31 May 2011

Re: Exhibition of second concept plan, M5 West Widening (Application: 100_0052)

Re: M5 West Widening Project (MP10_0052) - Exhibition of Preferred Project Report

Figure 8.7 Location of existing and proposed new or augmented noise walls

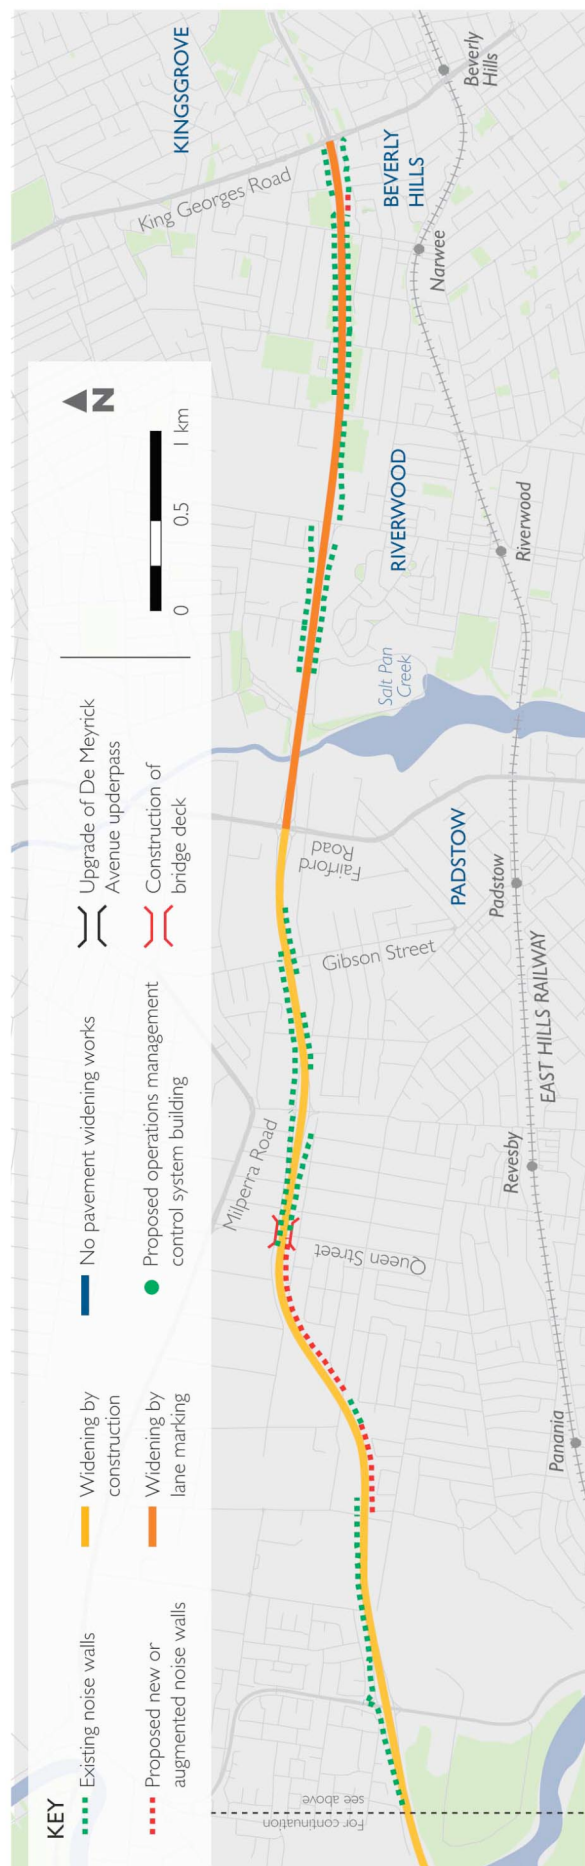
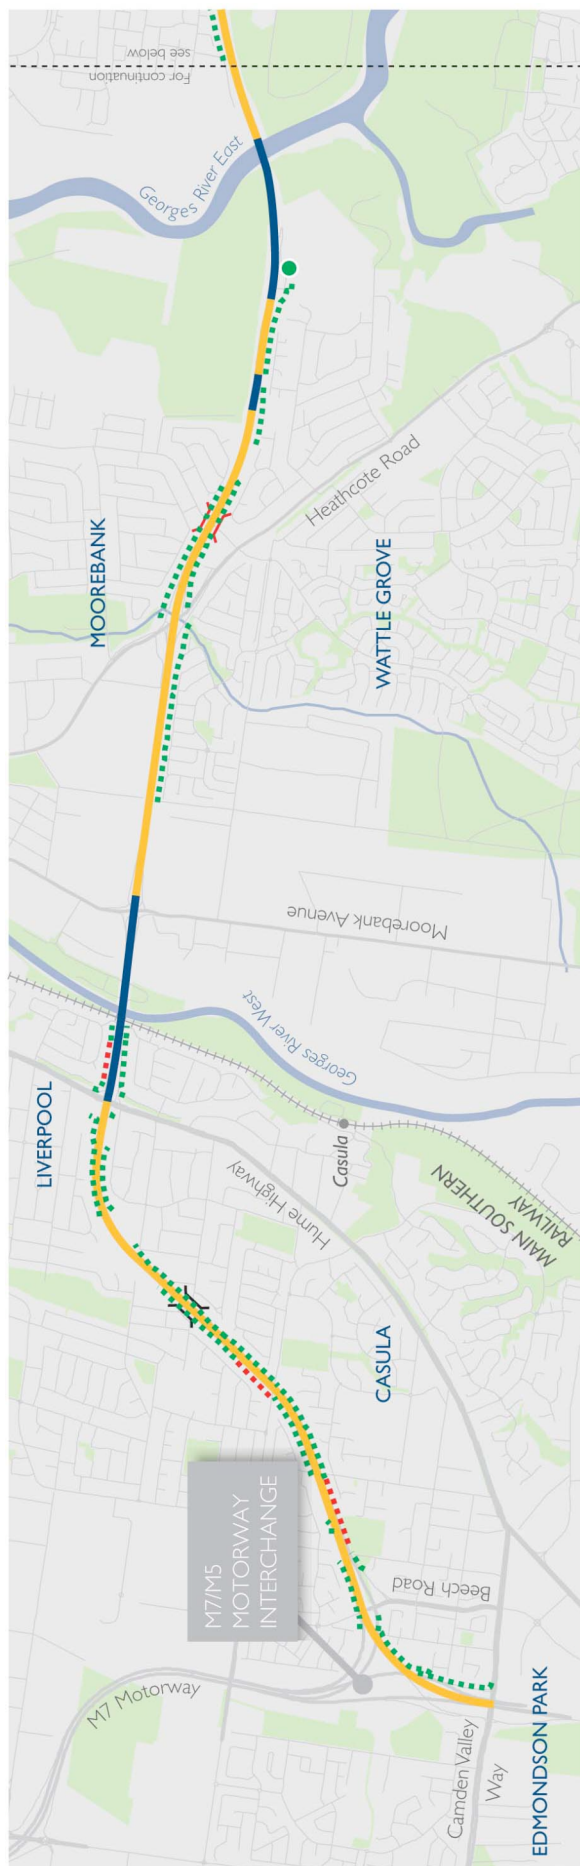
I write in regards to the M5 West Motorway widening proposal currently on exhibition until 1 June 2011. Council supports the proposal to upgrade the motorway however it is apparent that some of the primary concerns raised by Council have not been incorporated into the revised concept; namely the lack of noise barriers on the Georges River Bridge.

It is noted in the exhibition documentation that the sound level increases caused by the proposed upgrade will increase the sound levels at the Georges River Bridge by 2dBa. This is not insignificant given the already high ambient noise in this area. Council strongly urges that sound barriers are implemented for the full length of the Motorway in urban areas with barriers to extend over the Georges River Bridge.

The RTA's justification for the lack of noise walls for this section of motorway is that the affected dwellings are on the noise abatement list and that only a small number of dwellings are affected. This justification is not considered appropriate by Council particularly considering the additional noise generating projects proposed for the area including the South Sydney Freight Line, the proposed Moorebank freight intermodals and the additional mitigation works proposed at the Hume Highway Interchange.
